CITY OF ALBUQUERQUE

DRB Comments

PROJECT # 1003125

RE: Tracts D1A1 & D1A2 , Aerospace Technology Park

PLAT OF TRACTS D-1-A-1-A AND D-1-A-1-B
 OF
 BULK LAND PLAT
 FOR
 AEROSPACE TECHNOLOGY PARK
 WITHIN
 SECTION 36
 TOWNSHIP 11 NORTH, RANGE 1 EAST
 CITY OF ALBUQUERQUE
 BERNALILLO COUNTY, NEW MEXICO
 DECEMBER 2011

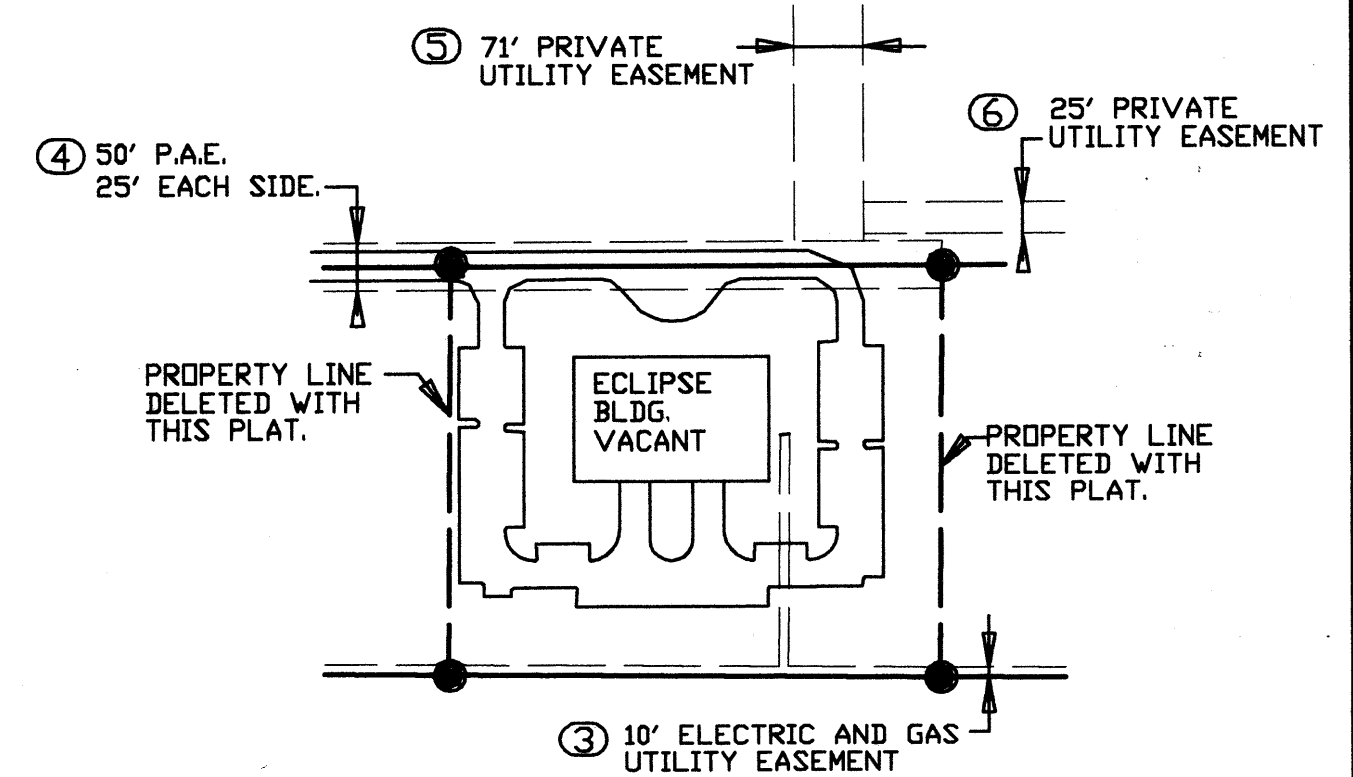
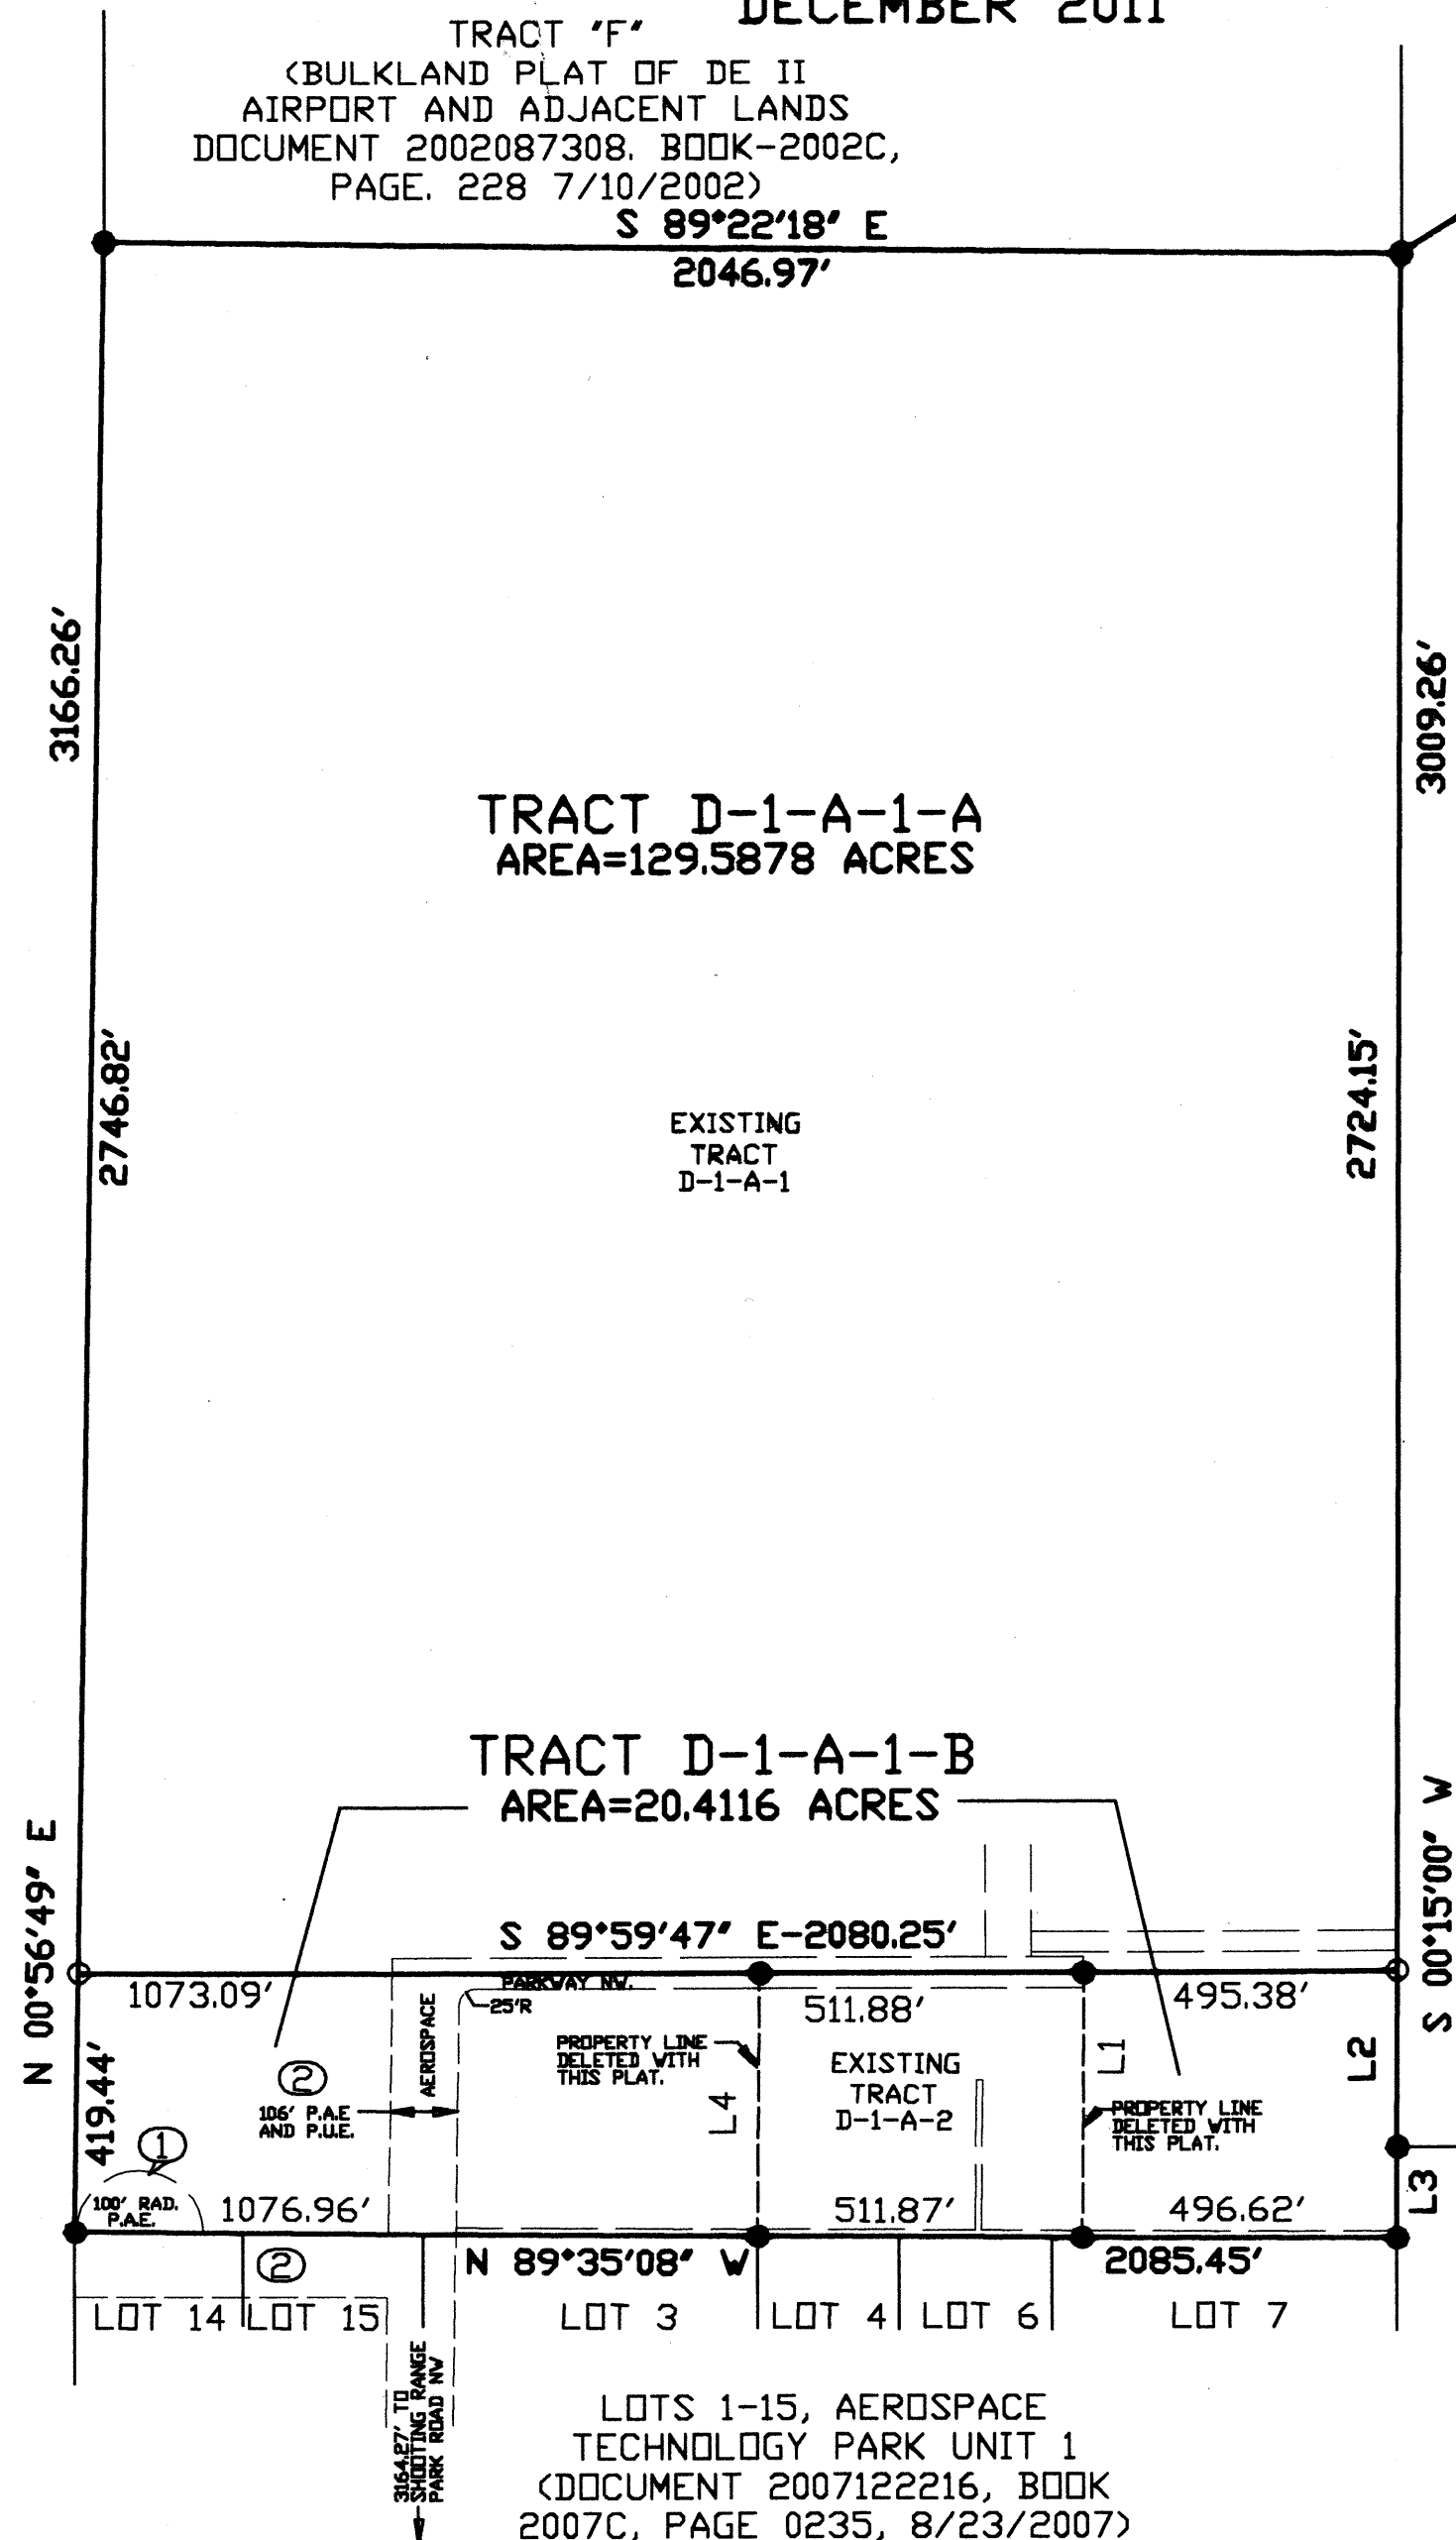
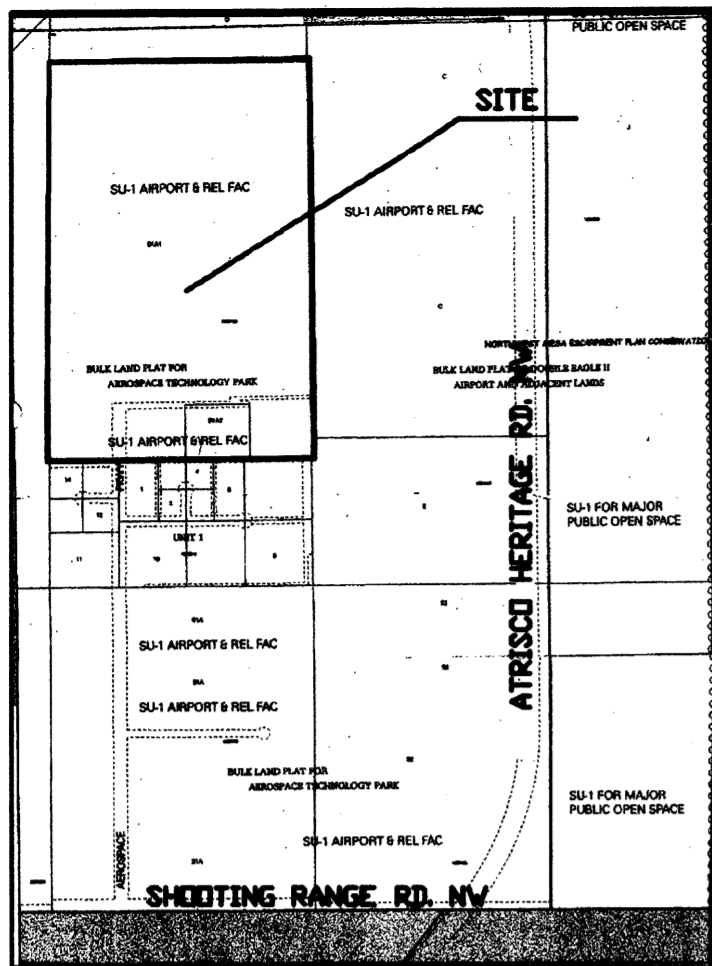
It appears the word "AMENDED" needs to be added to the title based on the existing plat for this property, or preferably (if approved by the City Surveyor) just delete the words "BULK LAND PLAT FOR."

The Plat title was revised to reflect the naming pattern of previous plats for Tract D, which included the word "Amended". The title was changed to, "Amended Bulk Land Plat for Aerospace Technology Park", on all three sheets. Also, the legal description was revised to reflect the new title and to further clarify the location of the property. Finally the owner's signature block was revised to included the line "For and on behalf of Ranch Joint Venture, LLP" and the title of the owner was changed according to the wishes of the City Legal Dept.
